**DELEGATED DECISION TO DETERMINE APPLICATIONS FOR
NON-MATERIAL AMENDMENTS**

Reference No: 2020/NM/92080/W

Site Address: 120, Laund Road, Salendine Nook, Huddersfield, HD3
3TY

Description: Non material amendment to previous permission
2019/90486 for demolition of existing dwelling and
erection of 7 dwellings

PLOT 2 PLANS

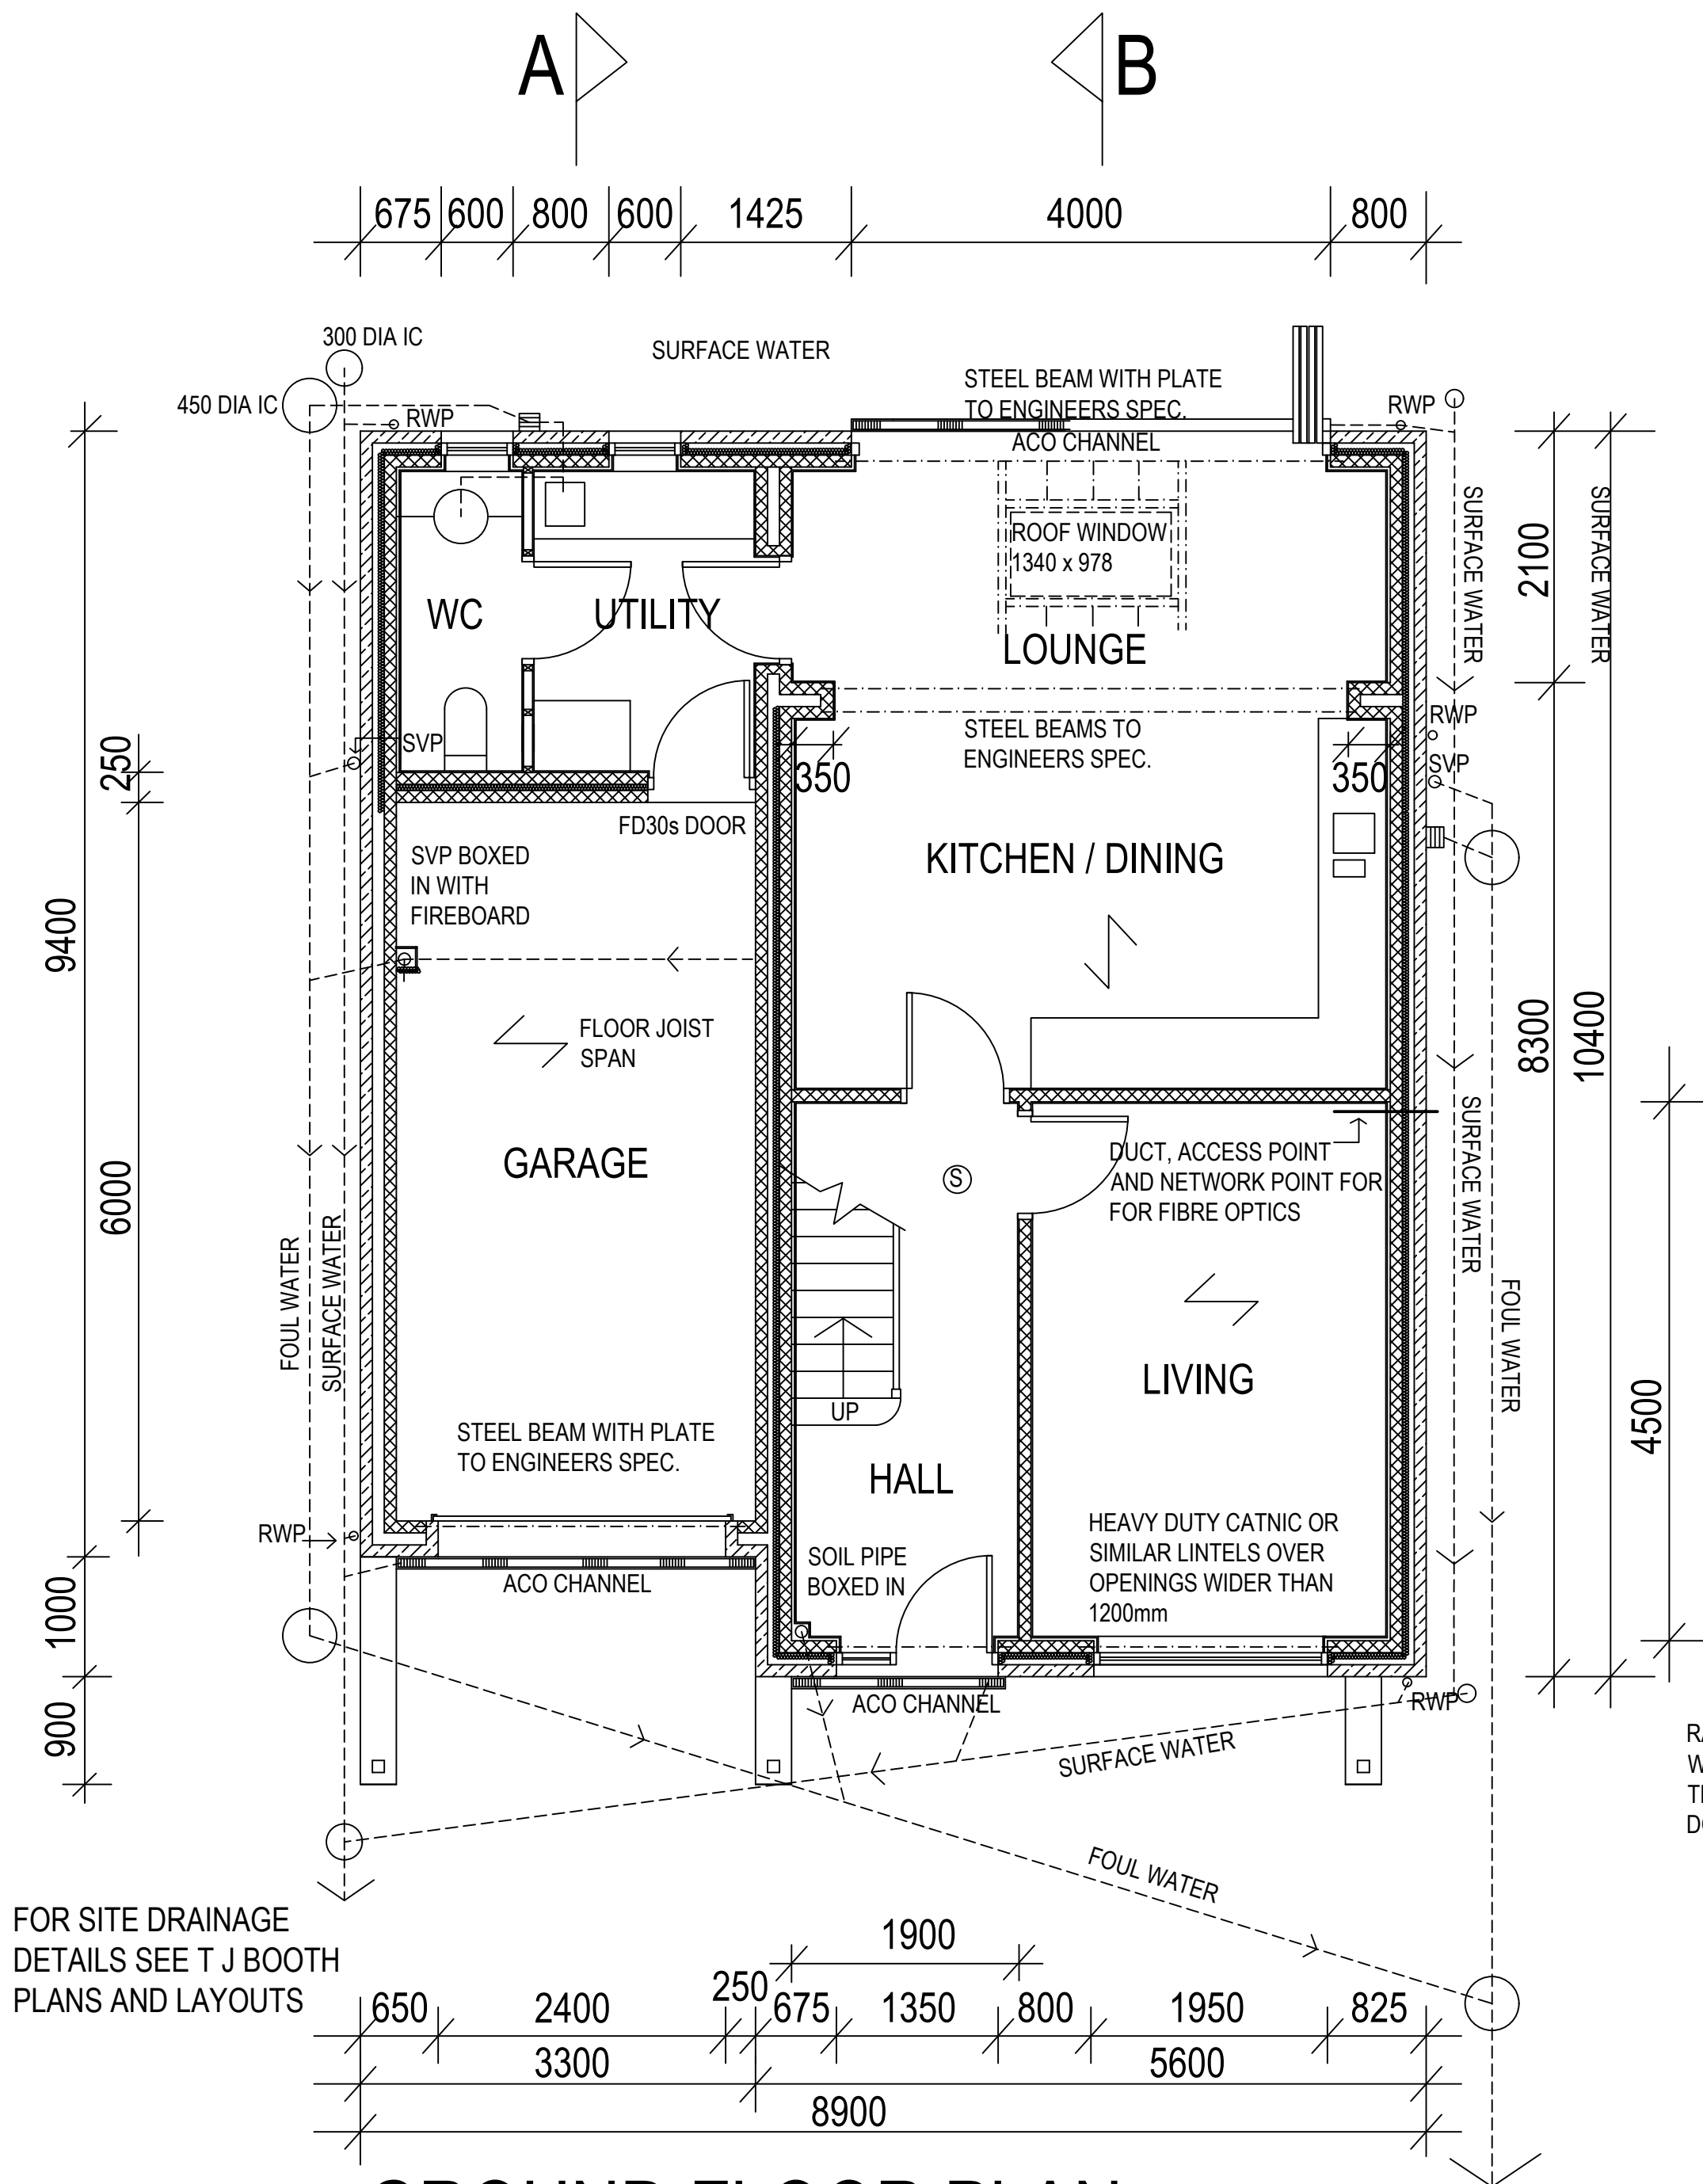
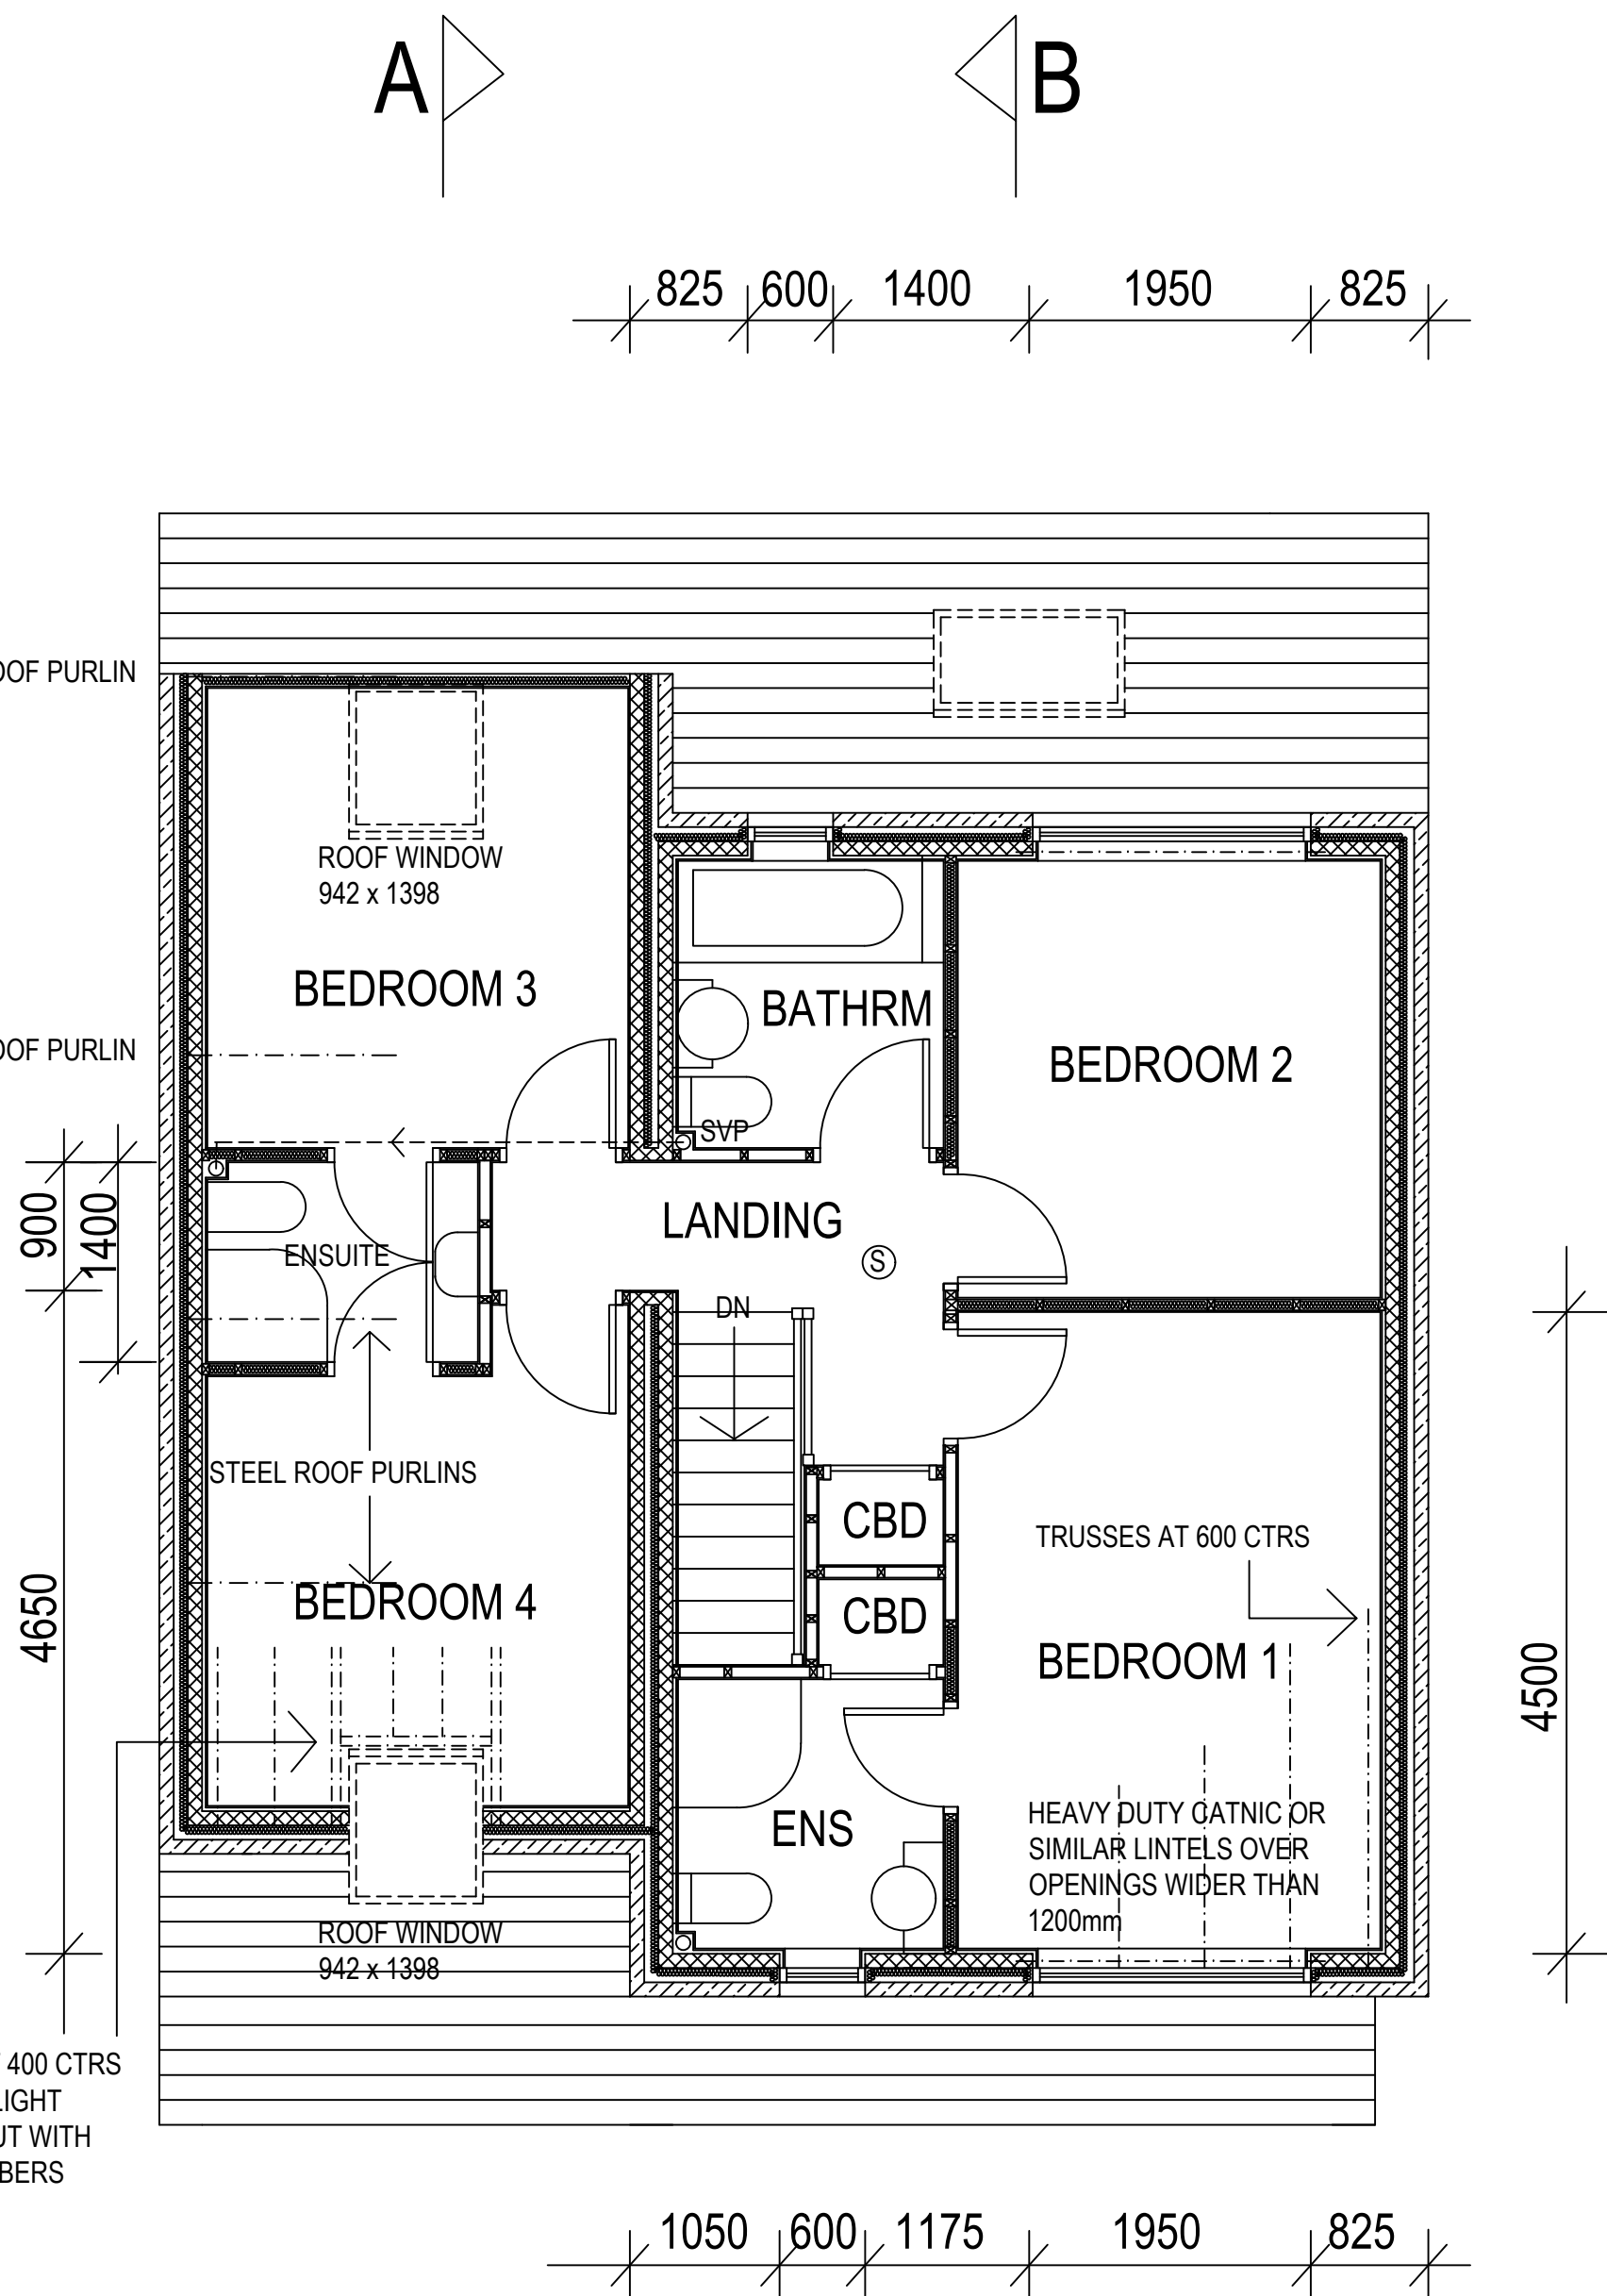
- The increase in overall height of plot 2 by 350mm.

This amendment is set out on the following drawings, Site Plan Dwg. No. 02 Rev B, Proposed Elevations Dwg. No. 11 Rev A, Proposed Floor Plans Dwg. No. 10 Rev A.
